AQUIND INTERCONNECTOR

Statement of Common Ground Between
AQUIND Limited and Historic England

Document Ref: 7.5.13

DATE: 15 FEBRUARY 2021

EN020022-2.11-PARA-Sheet1	Application document reference 2.11 Optical Regeneration Station(s) Parameter Plan Sheet 1 of 1
---------------------------	--

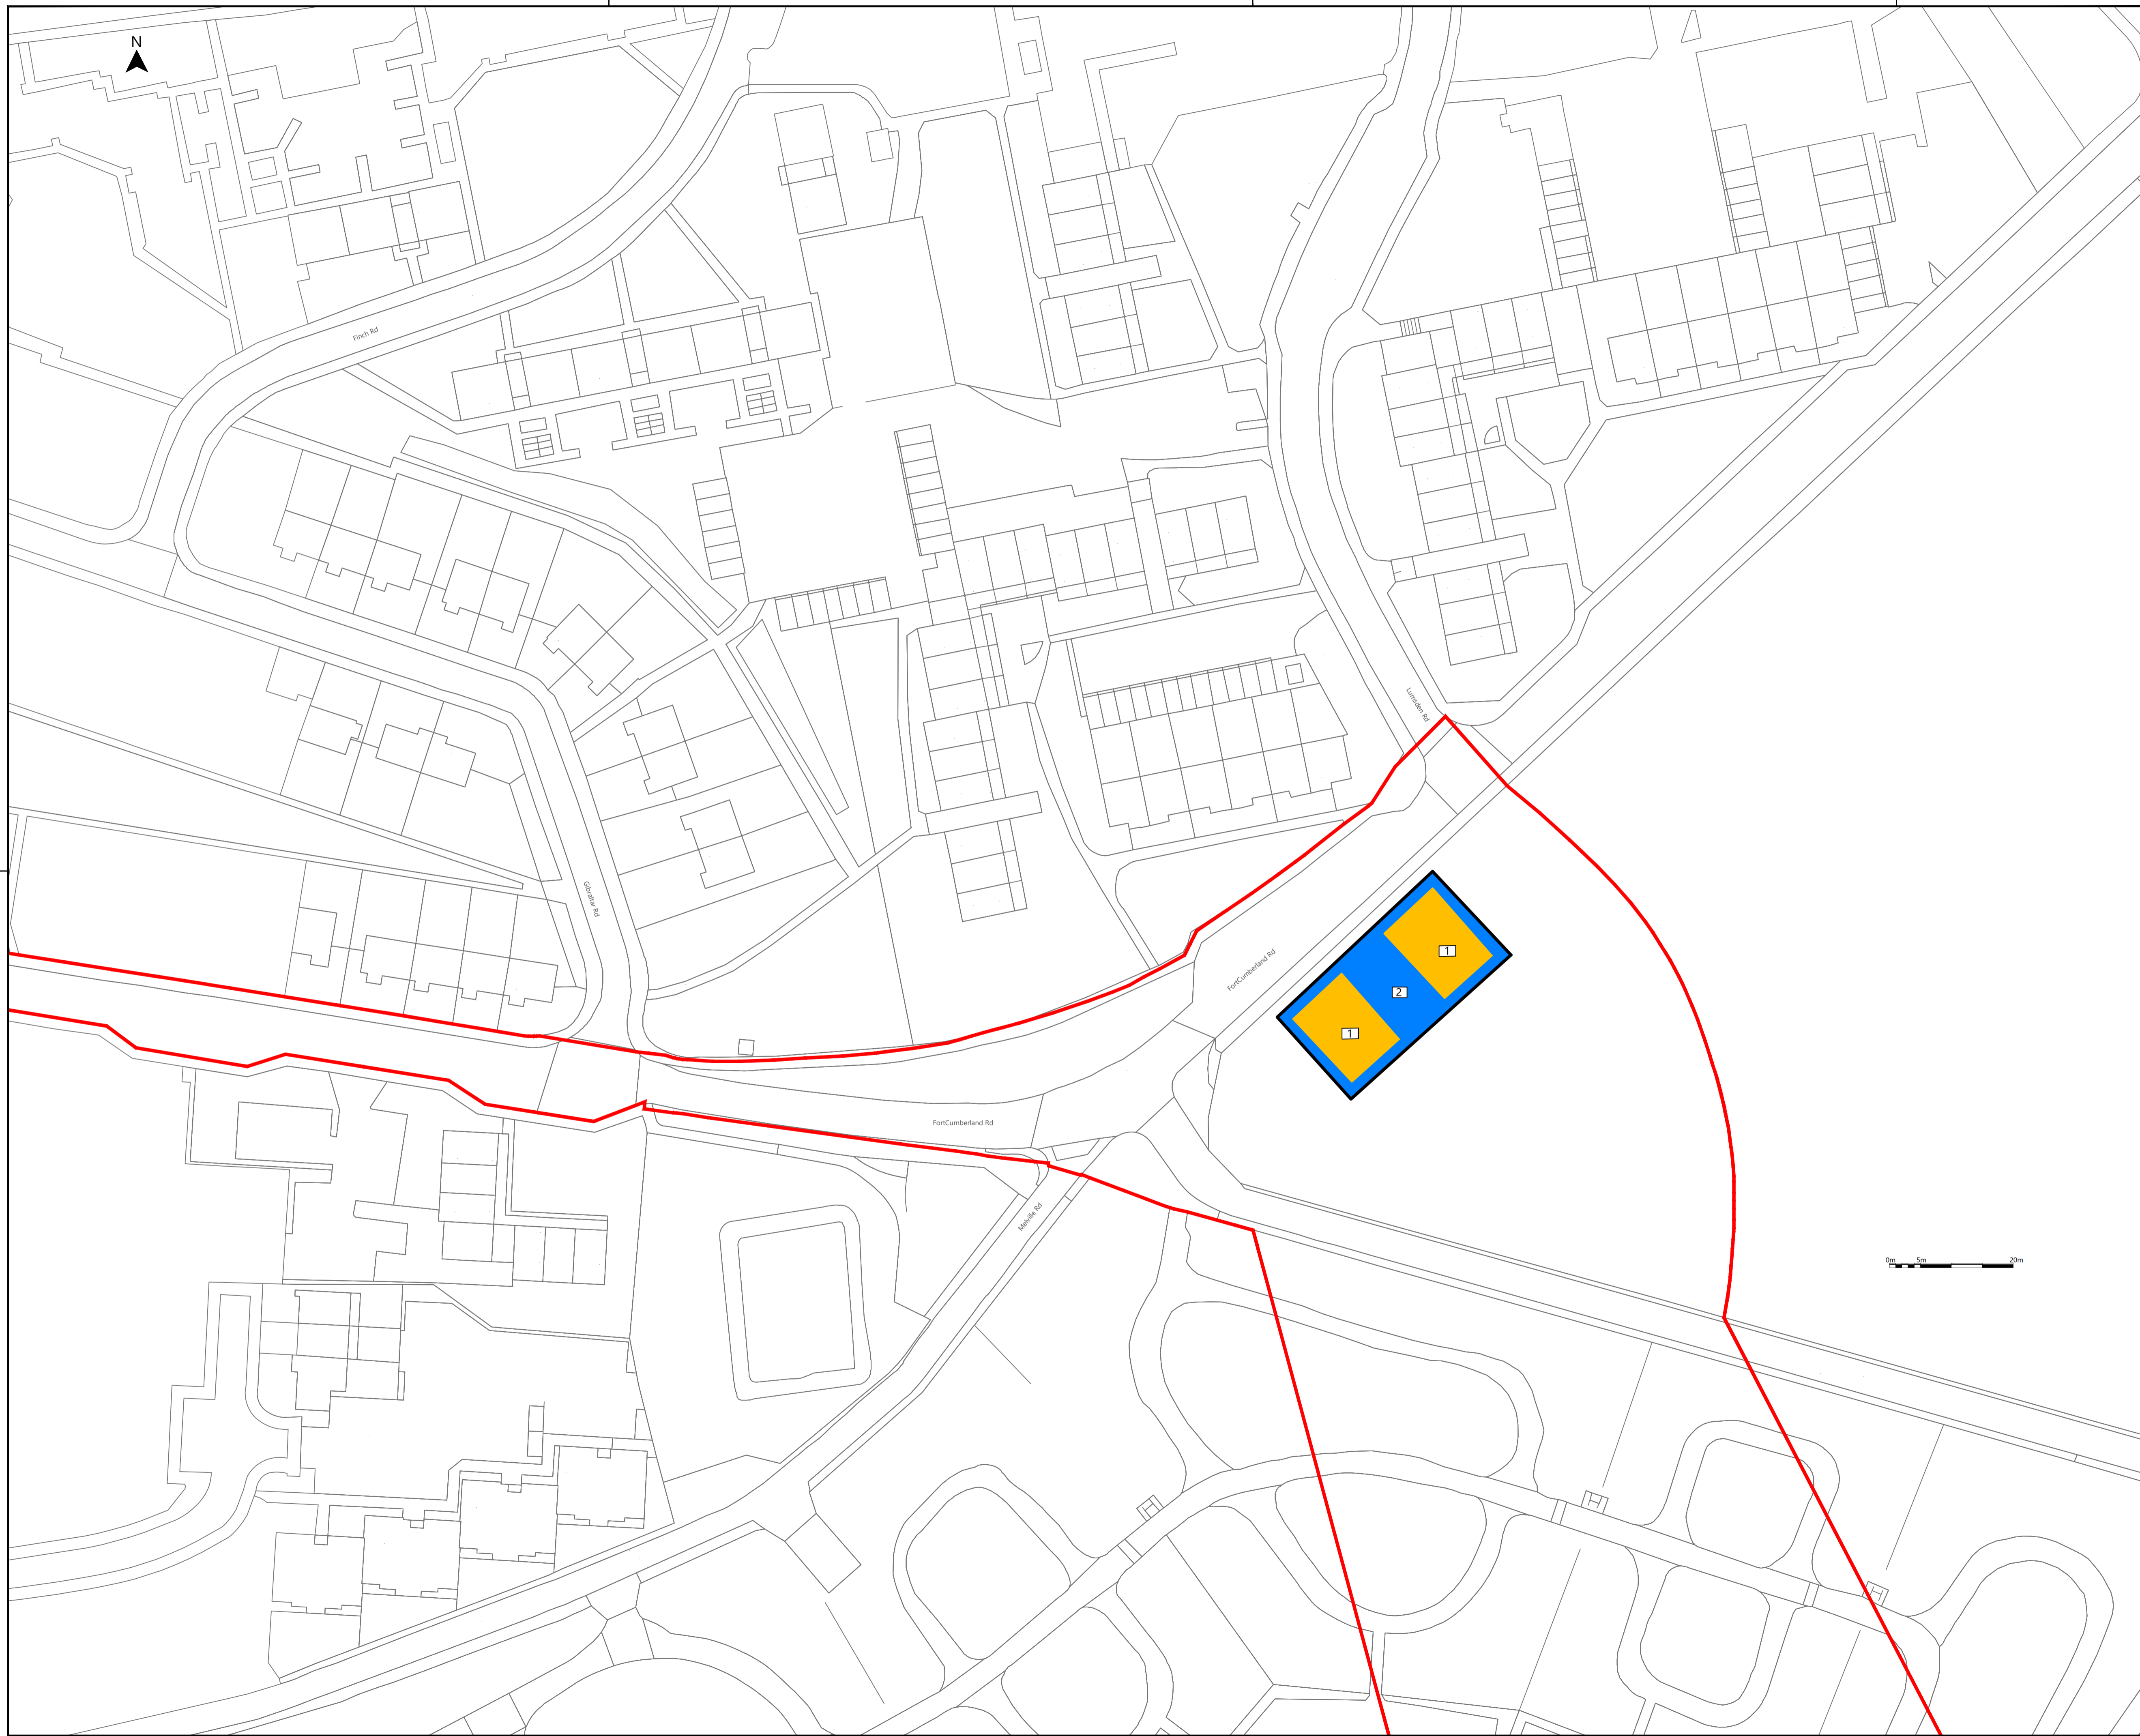
Ref.	Description of matter	Details of Agreement	RAG
		<p>appreciate and understand the landward approach to the site, via Fort Cumberland Road in particular, and its relationship with the monument. Historic England request to see the line of sight maintained to maximum extent, through the redesign or repositioning of the ORS.</p> <p>Outcome of further discussions</p> <p>This matter has been subject to further discussion between the parties following submission of the further visualisations contained with the ES Addendum at Deadline 1 (Document Ref 7.8.1). A teleconference meeting was held on 26 October 2020, where the additional submissions were discussed.</p> <p>Based on the additional information provided Historic England do not agree that the level of harm remains negligible and consider the impact to Fort Cumberland as ‘less than substantial harm’ (Overarching National Policy Statement EN-1 terminology). Historic England note that the visualisations do not provide an accurate representation of the view from the western ravelin itself, which is at an elevated position. As such, there is a possibility that the road convergence would be visible over the buildings from the ravelin, but this cannot be confirmed without a viewpoint from the ravelin itself. Historic England consider that the visualisations indicate (combined with viewpoint photos from the ravelin) that there would still be an impact on the view of Fort Cumberland Road even from the higher point.</p> <p>It has been agreed between the parties that the proposed Optical Regeneration Station (ORS) would not result in substantial harm to the Fort Cumberland Scheduled Monument and Grade II* listed building (see 3.1.5). Historic England maintain that the level of harm is less than substantial whilst the applicant considers the overall effect to Fort Cumberland scheduled monument is negligible. Irrespective of this differing professional opinion, in EIA terms the proposed change would not constitute a ‘significant’ environmental effect warranting substantial design amendments to the proposed scheme.</p> <p>The applicant will continue to consult with Historic England regarding reserved matters relating to building design such as materials and palette but do not consider further assessment work necessary. Following further discussion with Historic England, it was agreed that the draft DCO</p>

Ref.	Description of matter	Details of Agreement	RAG
		<p>text would be amended to make provision for consultation on reserved matters relating to the construction of the ORS. The proposed draft text was subsequently agreed by both parties.</p> <p>As outlined in Section 5.8 in (EN-1) it will be for the examining authority to decide whether any perceived harm has clear justification, in order to weigh that perceived harm against the public benefits of the development. The applicant makes note of the Needs and Benefits Addendum (Document Reference 7.7.7), which outlines the national scale benefits of the Aquind Interconnector.</p>	
4.1.6	Residual Effects	The residual effects identified in section 21.9 and table 21.6 of Chapter 21 of the ES (Heritage and Archaeology) (APP-136) are agreed.	Agreed
